Our Ref: AB/135/19/HH
Your Ref:

Town & Country Planning Act 1990 (as amended)
Town & Country Planning (Development Management Procedure) (England) Order 2015
Application for Planning Permission for Works or Extension to a Dwelling

Development Proposed internal and external alterations to existing building at The Old Wheatsheaf, 31 Maltravers Street, Arundel, BN18 9BU including replacement of selected windows and doors and new ground floor terrace to provide more flexible family living accommodation and a lower ground floor annex.

Location 31 Maltravers Street Arundel

2 Site Block Plan
Scale: 1:500

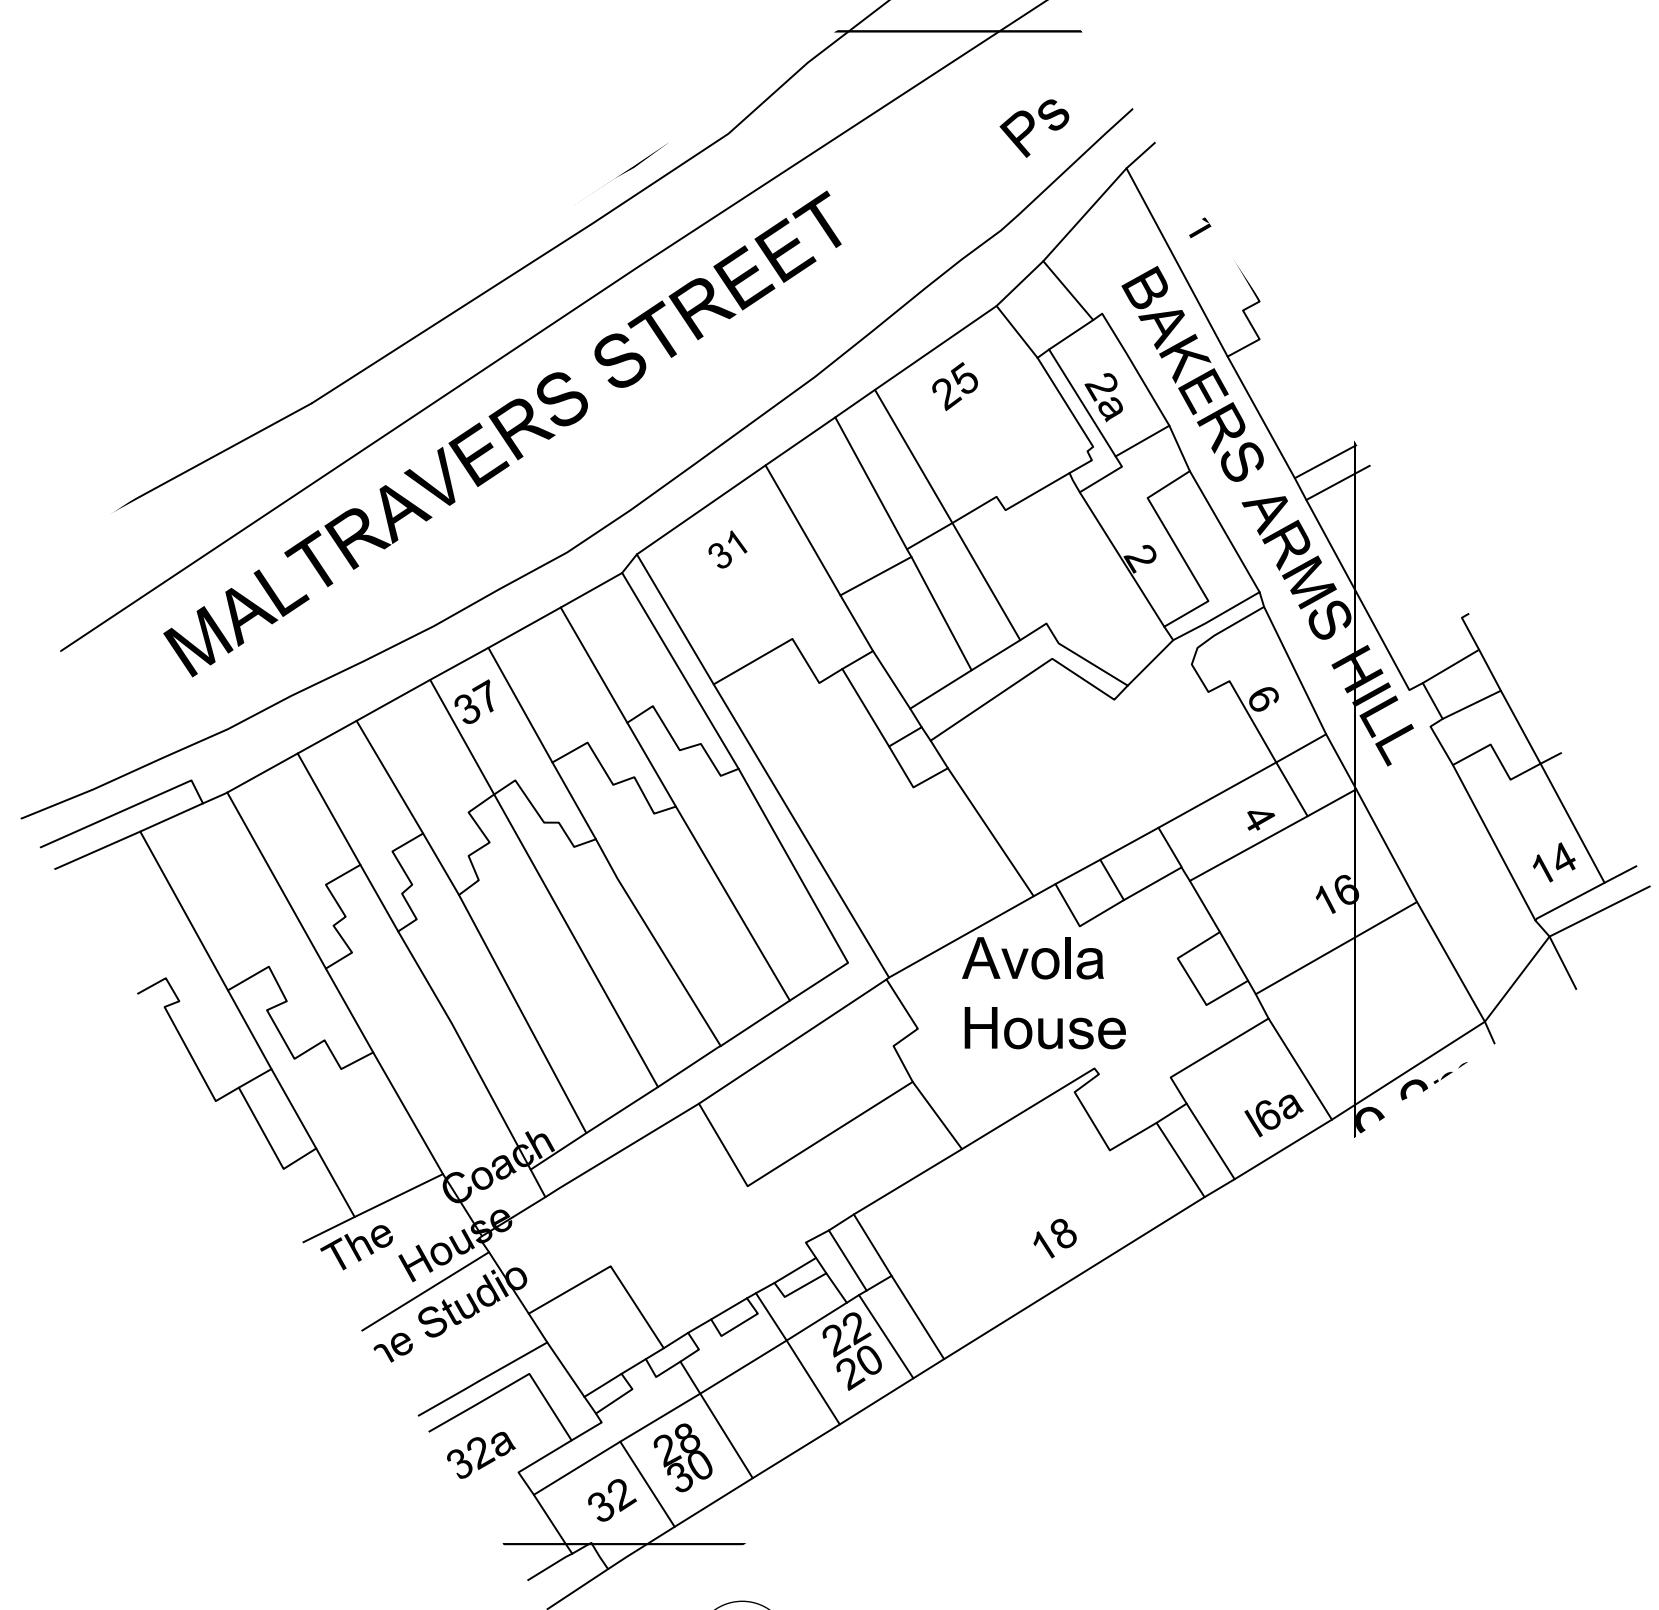
Dimensions: You are required to include dimensions on the block plan from the proposed extensions to all site boundaries.
